Application no: H22-0372-15**Applicant:** Market Deeping Building Co Ltd
33 High Street
Market Deeping
Peterborough
Cambs
PE6 8EDCouncil Offices
Priory Road
Spalding
Lincolnshire
PE11 2XE**contacts:**admin: 01775 764723
dc officers: 01775 764703
s/board: 01775 761161
facsimile: 01775 762937**Agent:** G R Merchant Ltd
Unit 4 Wrights Mews
12A Park Road
Holbeach
Spalding
Lincs
PE12 7EE**Description:** Erect 2 dwellings - outline application H22-0853-14**Location:** 92 BROADGATE
WESTON
SPALDING
PE12 6HY**Amendment:** Bungalow on Plot 1 moved 0.5 metres away from northern boundary, retain sycamore & holly tree (dwg. nos. 01B+02B)**Letter Sent:** 12th May 2015

ACKNOWLEDGEMENT OF AMENDMENT

**ERECT 2 NO DWELLINGS
92 BROADGATE, WESTON, PE12 6LY**

Drawing
SITE & LOCATION PLANS - EXISTING.

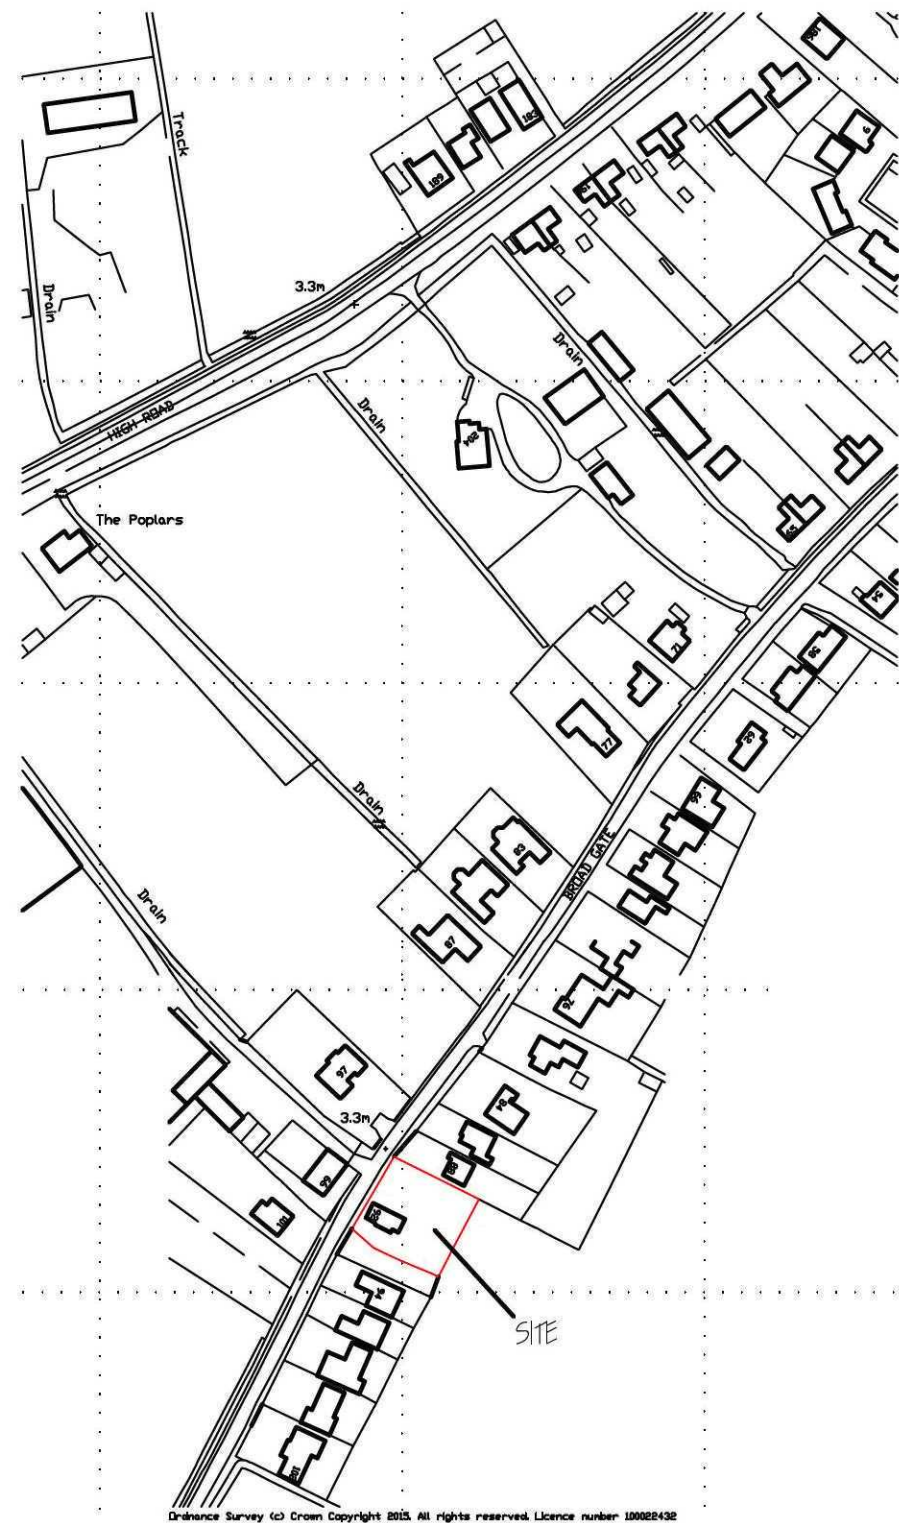
Bungalow on Plot 1 moved 0.5 metres away from northern boundary, retain sycamore & holly tree (dwg. nos. 01B+02B)
